Your Ref: OWPC19314
Our Ref: K/23/18/PL 12-06-2018
Please ask for:
Mrs A Gardner

Demolition & erection of 1 No. dwelling with swimming pool.
Little Deerswood Gorse Avenue East Preston

Thank you for your internet representation made on 16th July 2018 which has been recorded as '**an objection**' with the comments as follows:

Second Floor & Roof Plans as proposed

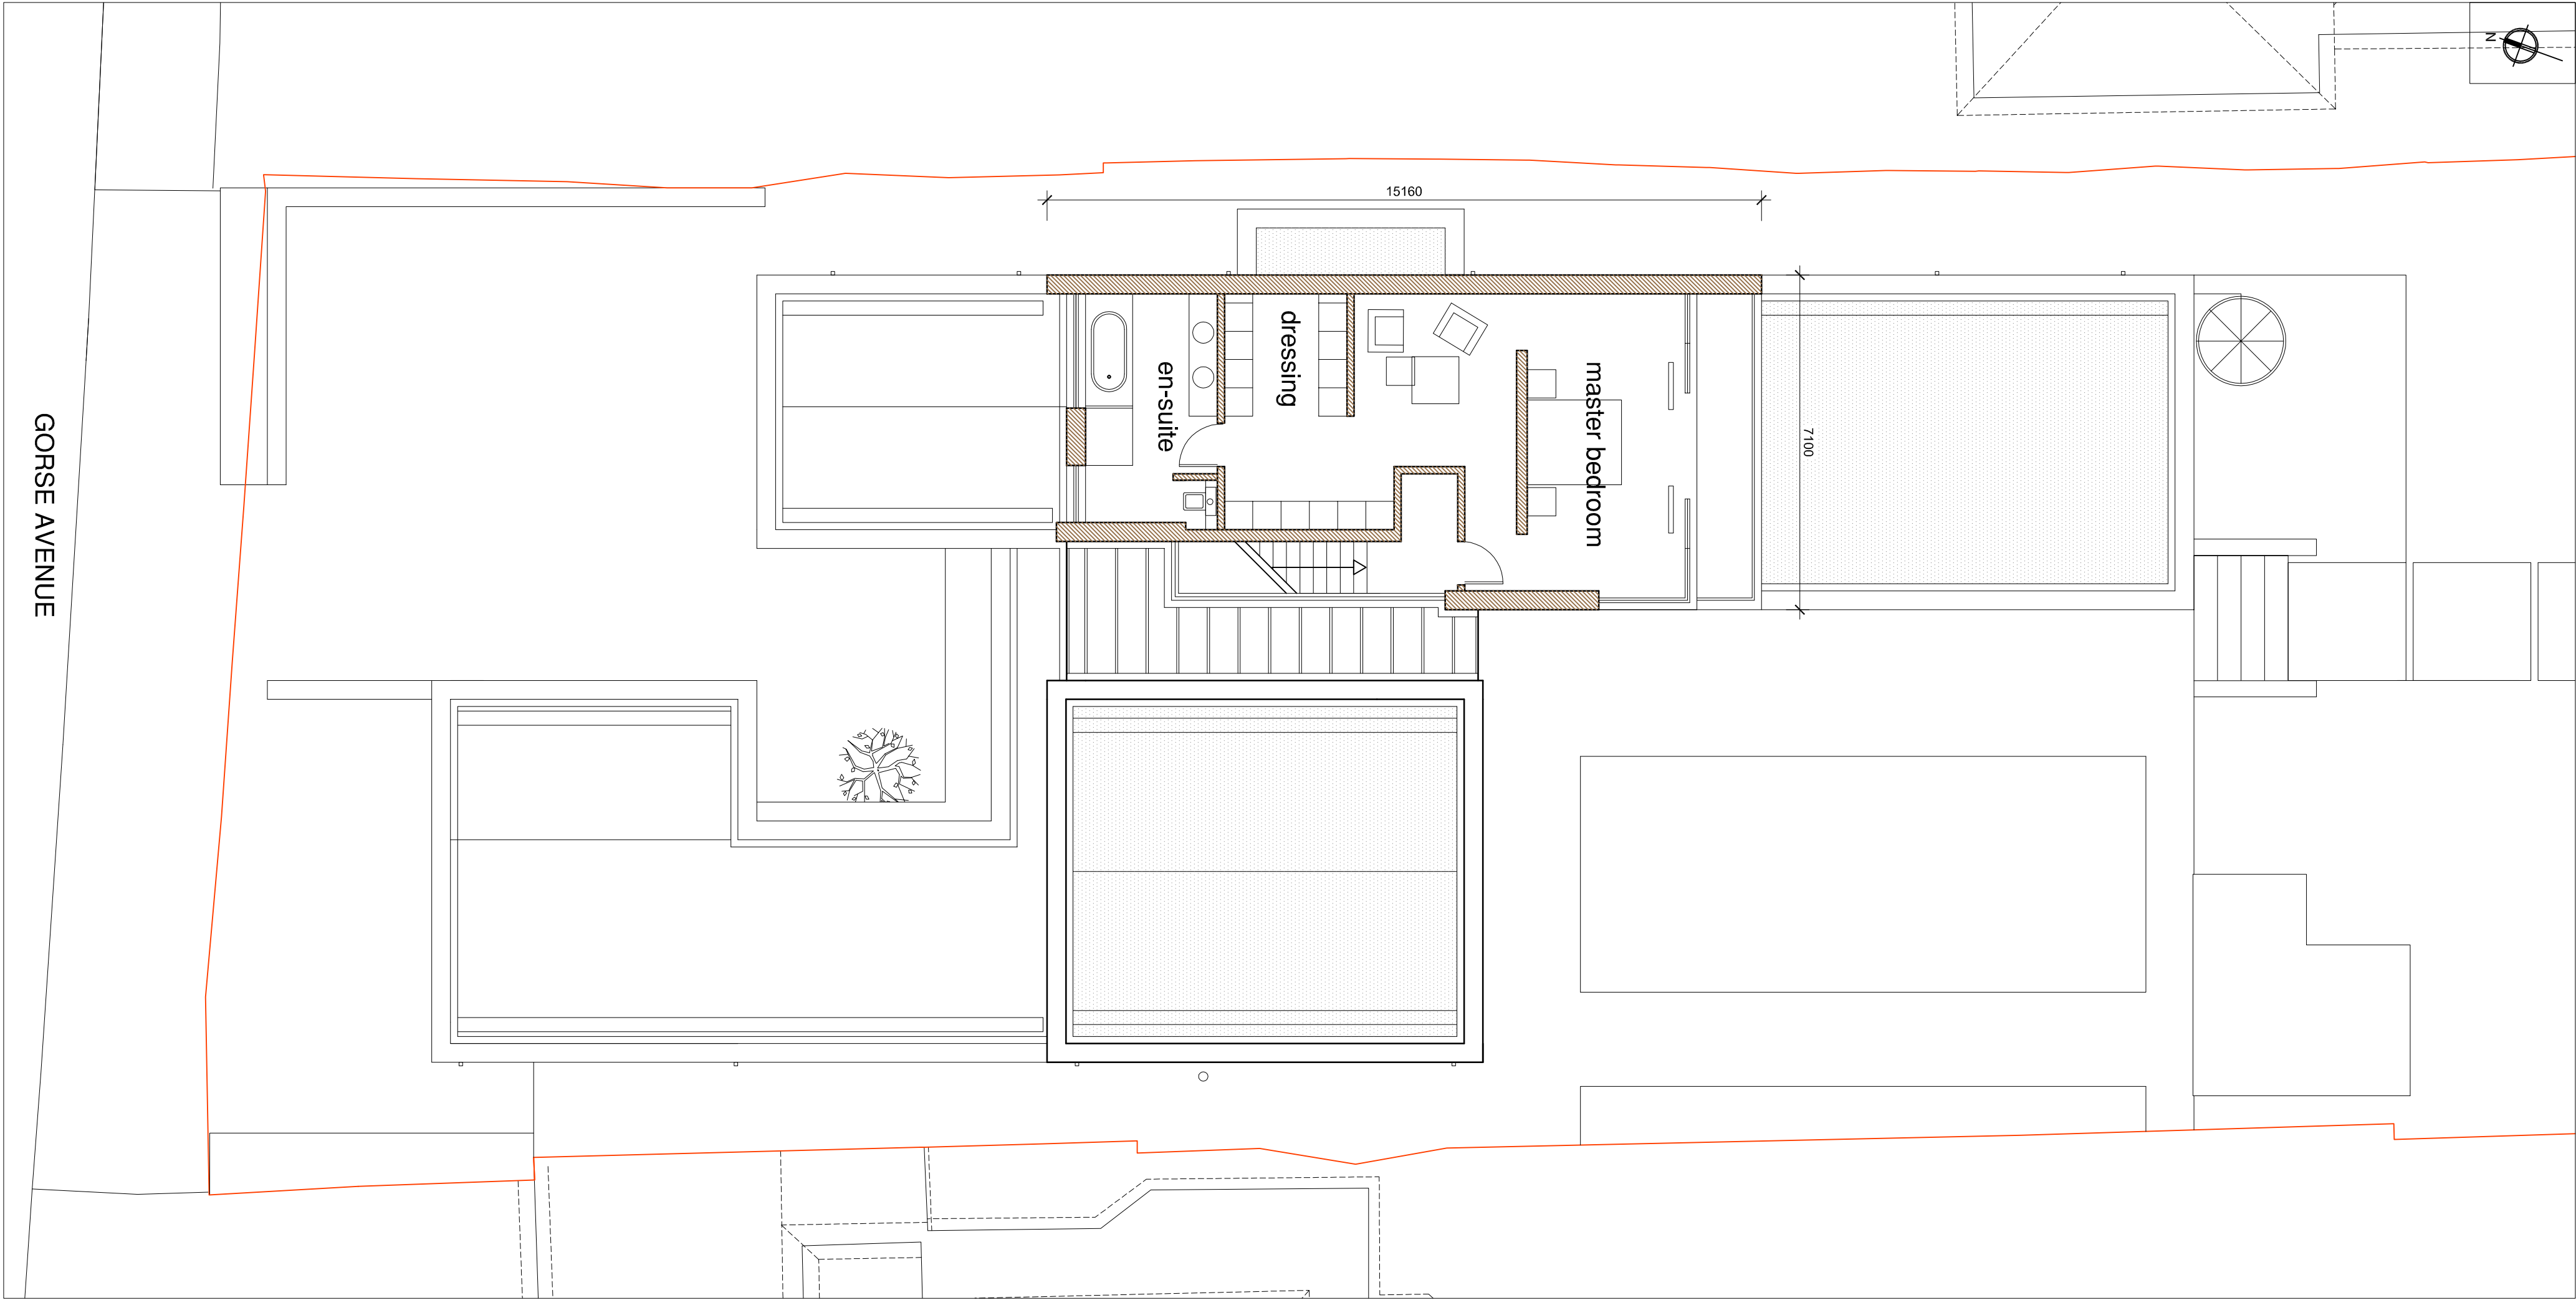
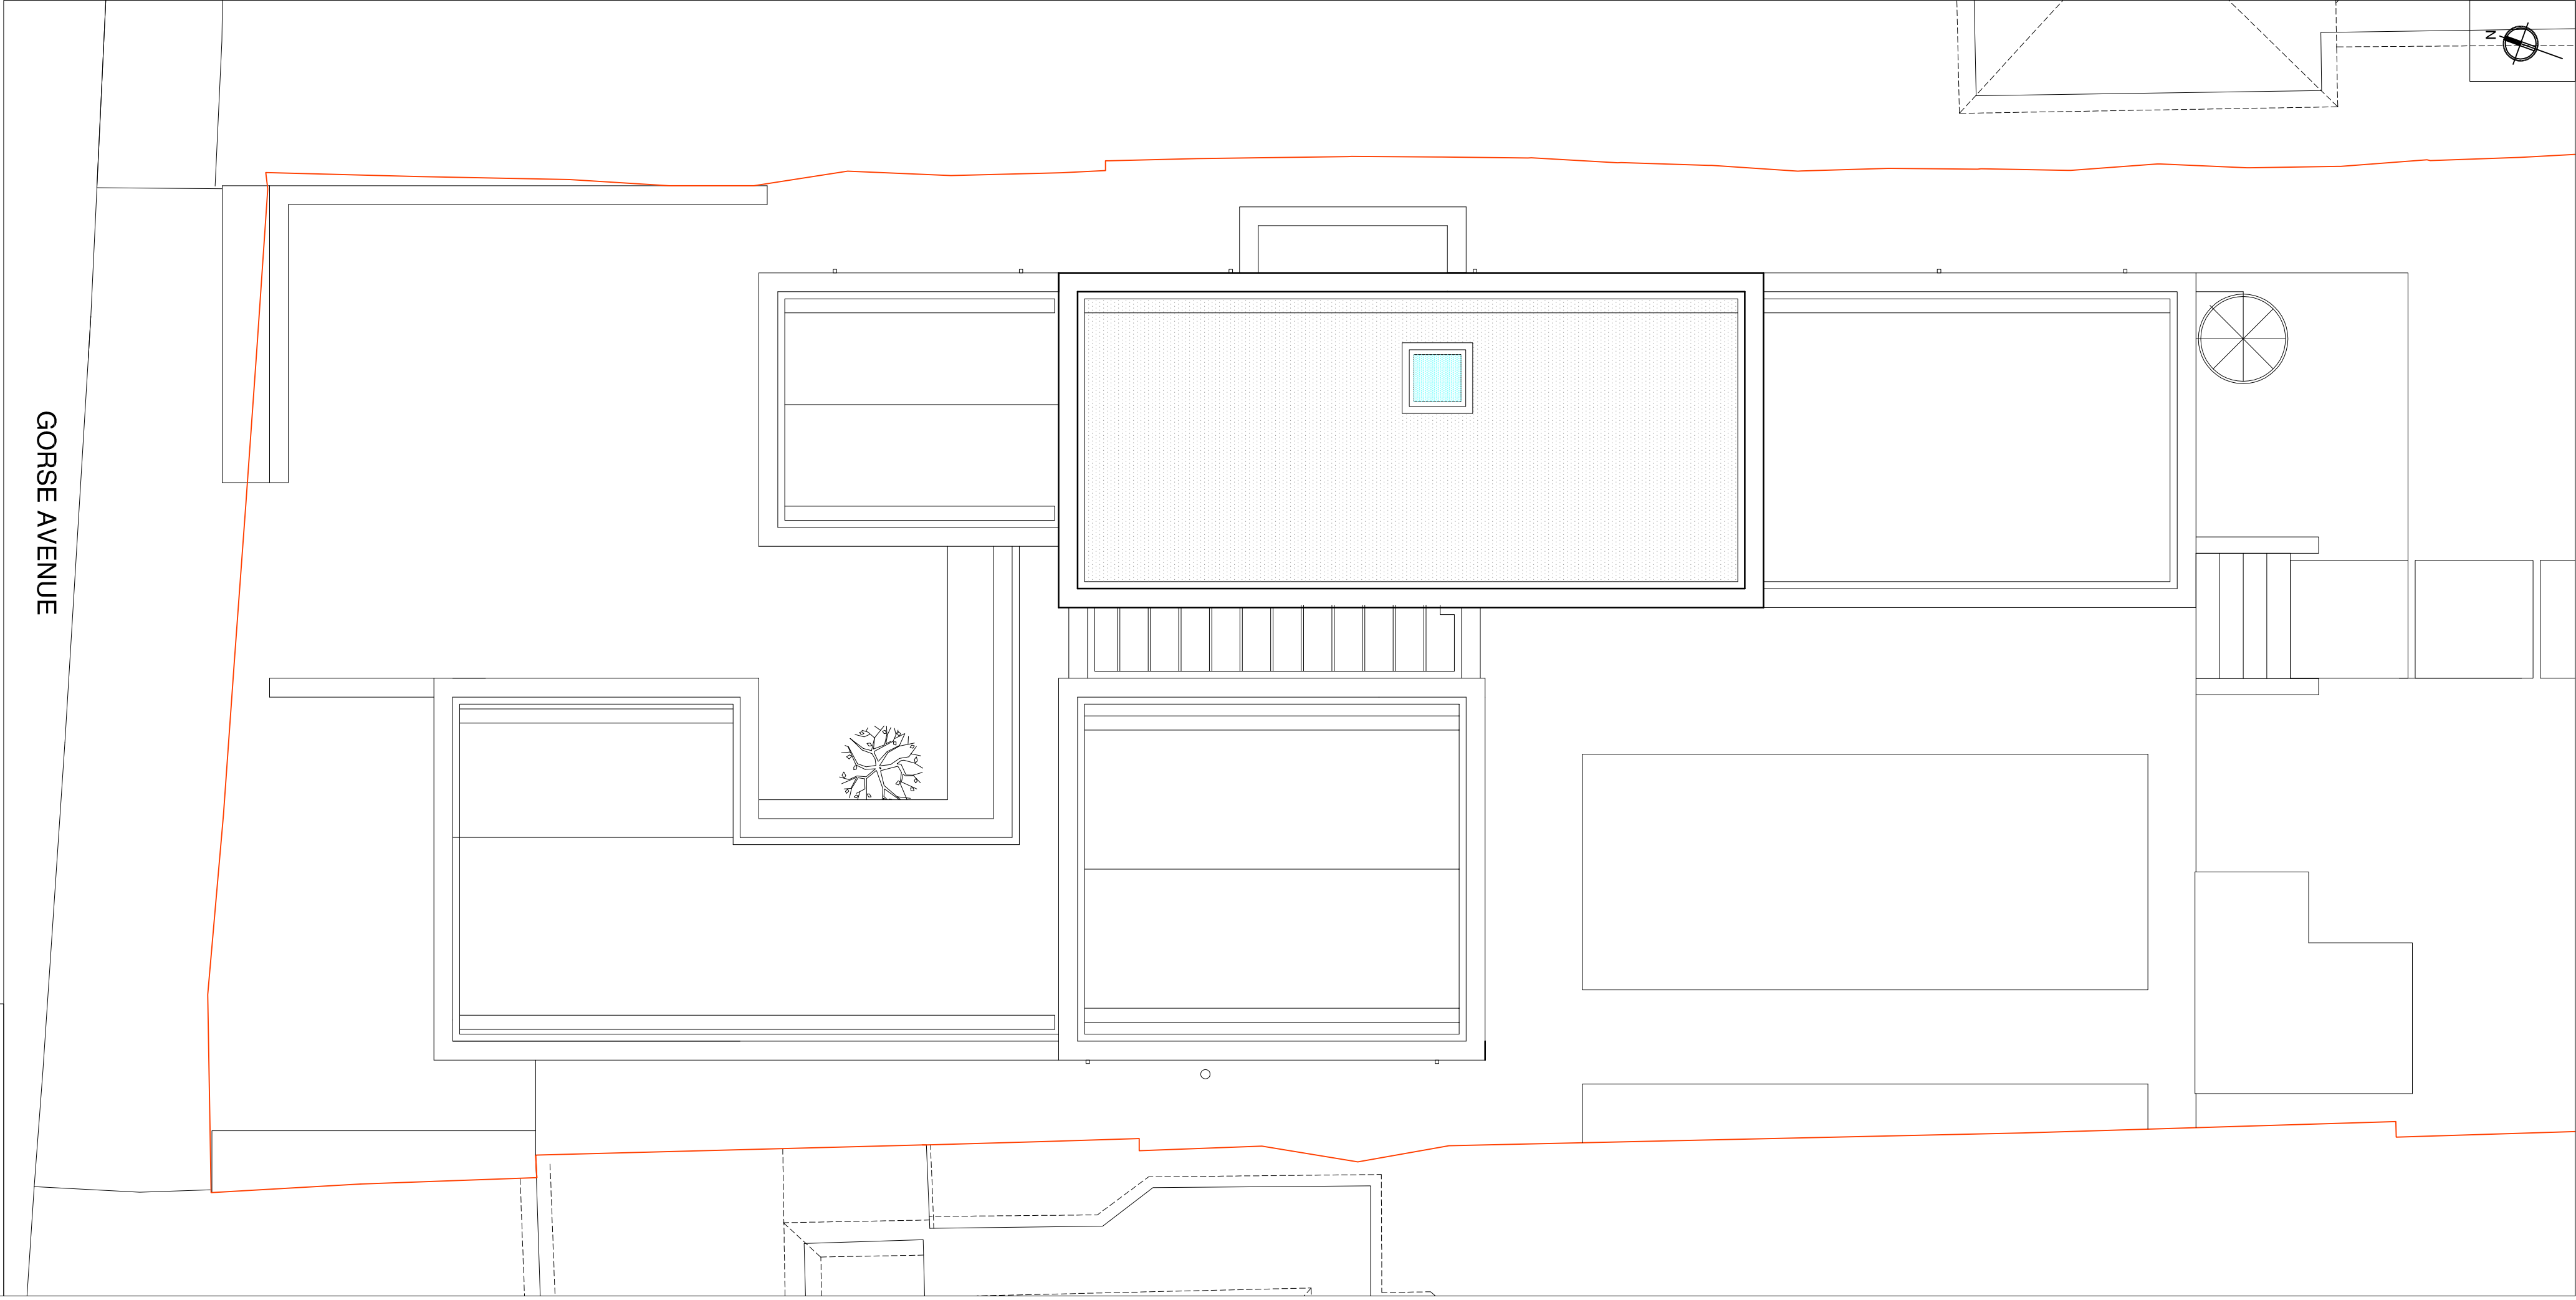
*The extension of this dwelling to the east and increasing it to 3 floors impacts my privacy significantly.
The plans submitted increase window space to the north which overlooks my property.
Contrary to point 5.3 on the planning statement, The plans do not improve visual separation between buildings, they merely create loss of gaps between dwellings and a higher building which make this an intrusive and overbearing application and results in significant loss of my families privacy.*
